**FW: LU/29/26/PL**

Many thanks for your recent submission for **25 River Road, Littlehampton**, which has been allocated to me for determination.

DRAWING NUMBER  
2024.423.04

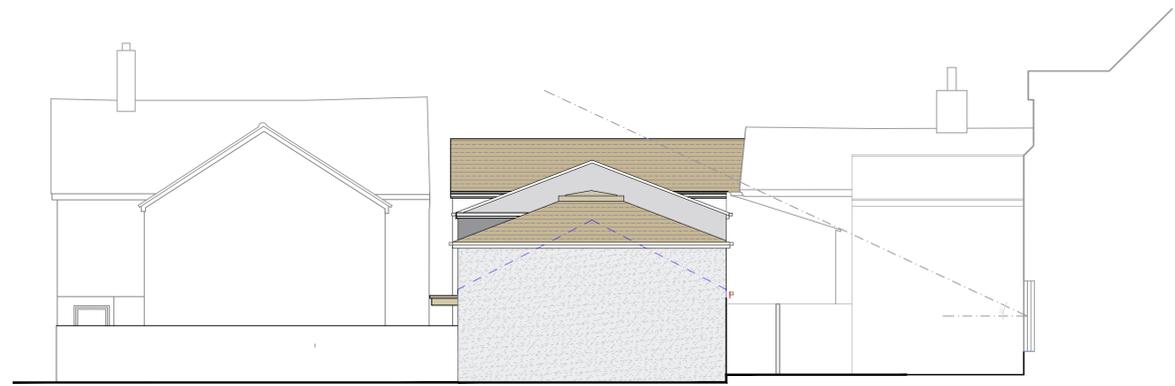
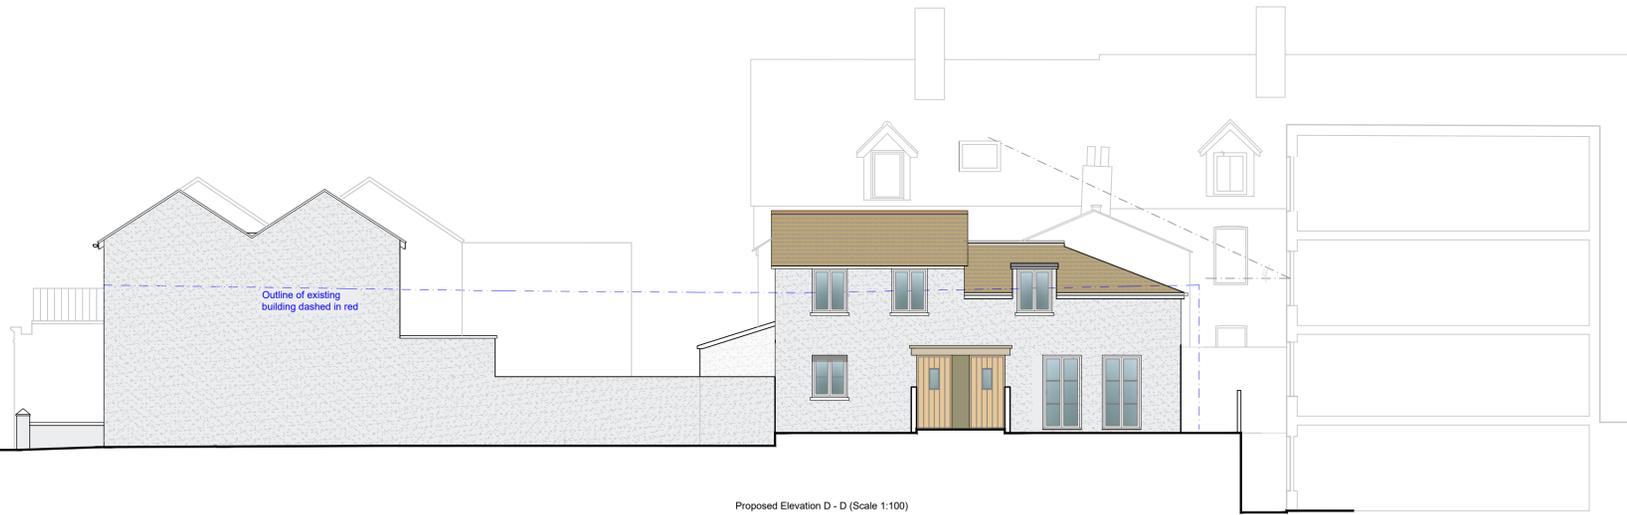
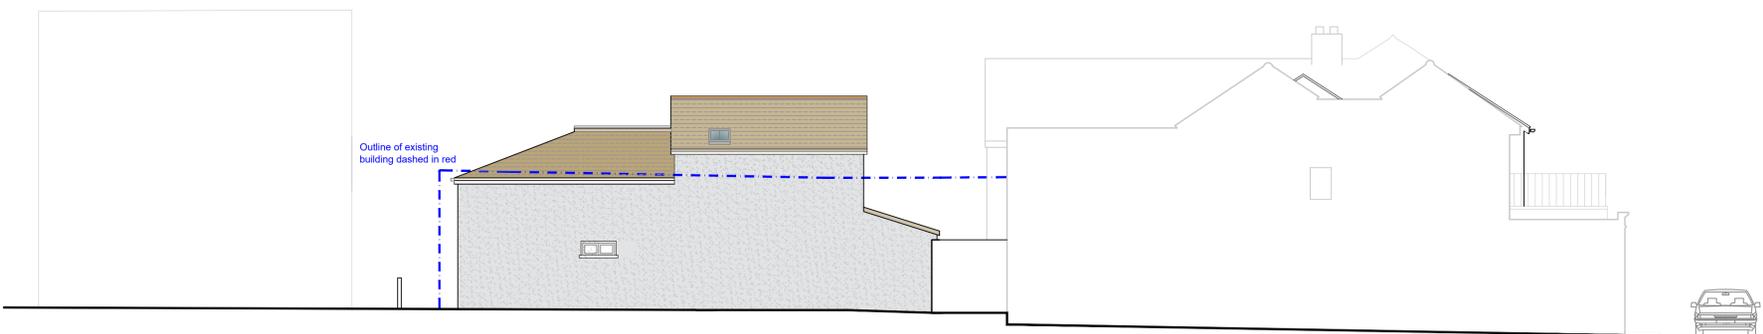
- Sections through the buildings
- Indications of head heights at first-floor level on the plans (particularly for Plot 3)
- A topographical survey

Thank you for the email, yes I am happy to provide the information in point 1 & 2 below however can I ask why you need a topographical survey, this was never requested in the original application which sat 1.5m higher, also we have shown the difference in levels on the elevations drawings where you can see the rear plots sit slightly higher (about 400mm higher than the front ones). A full topo will cost additional consultation fees and also take weeks.

drawing number
2024.423.05

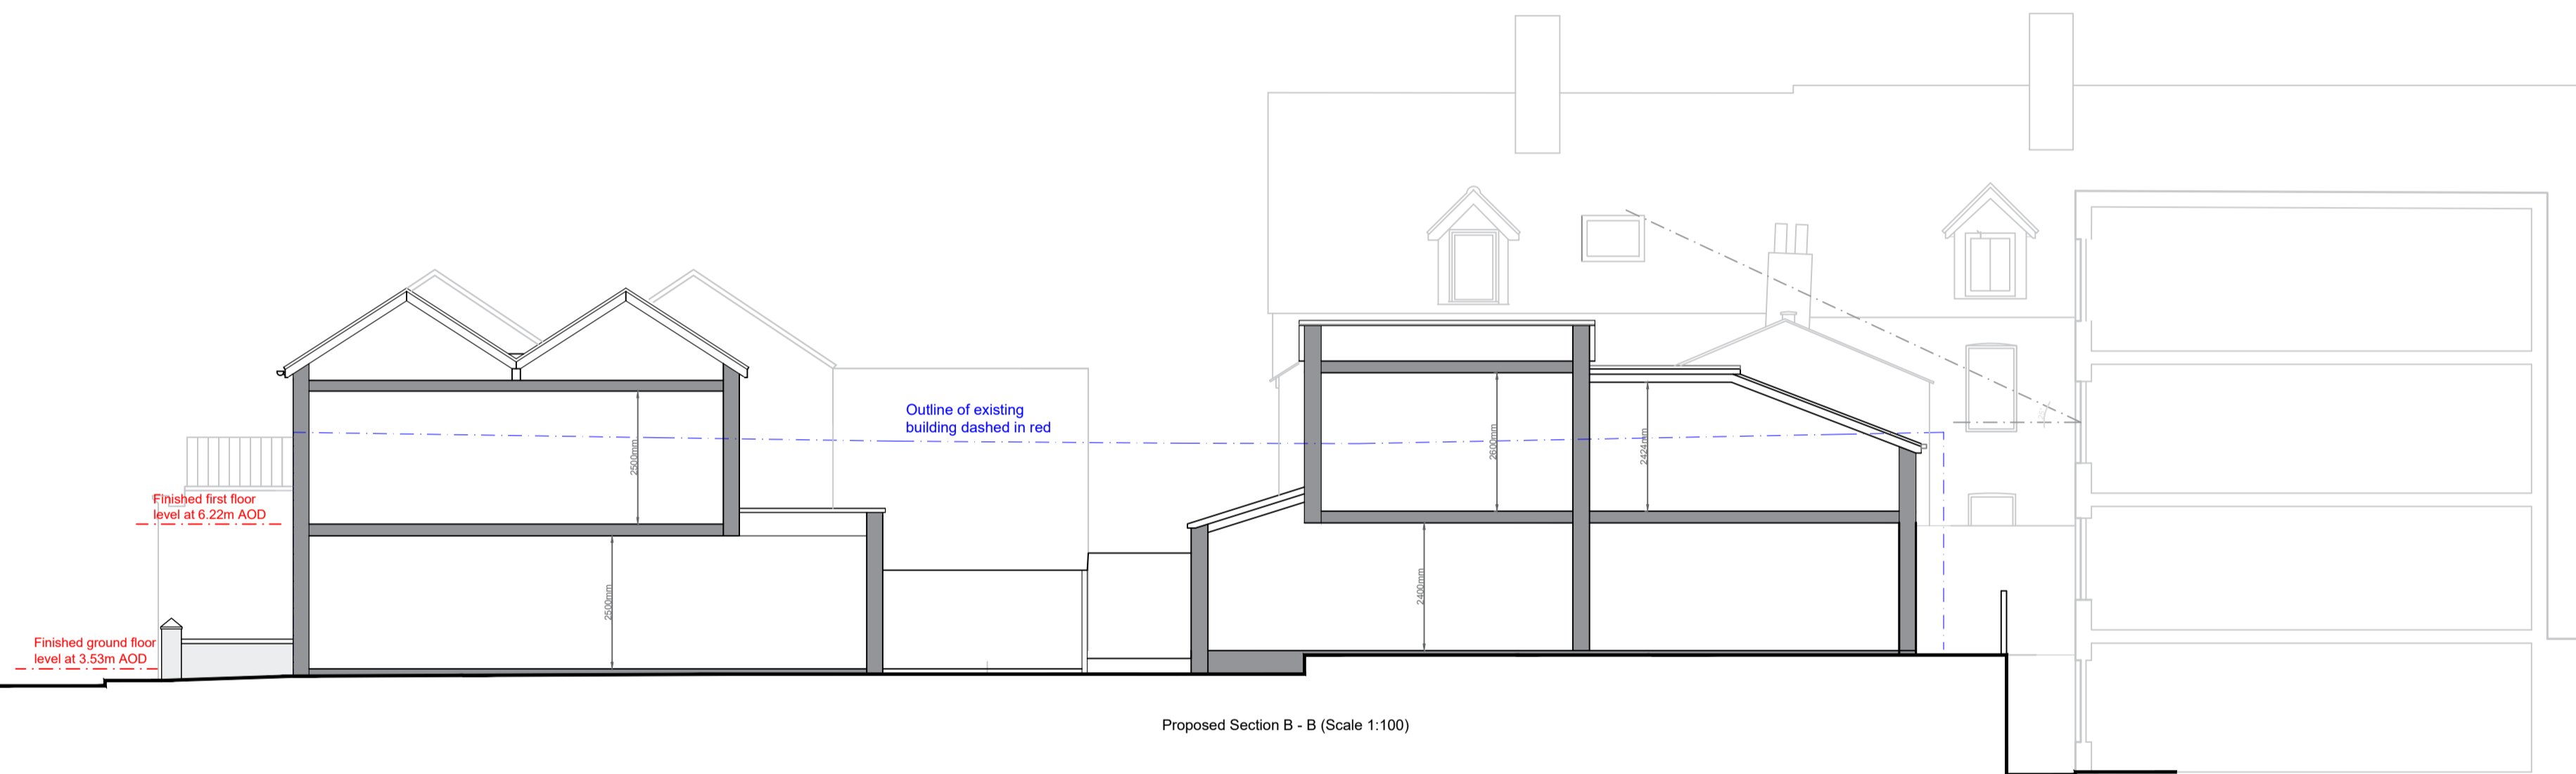
Ok, would it be possible to annotate the sections with the level information you have to hand i.e. floor levels etc.? If this information could link with the FRA in terms of AOD levels this would be helpful.

Please find enclosed the section drawings with proposed floor levels on as requested.
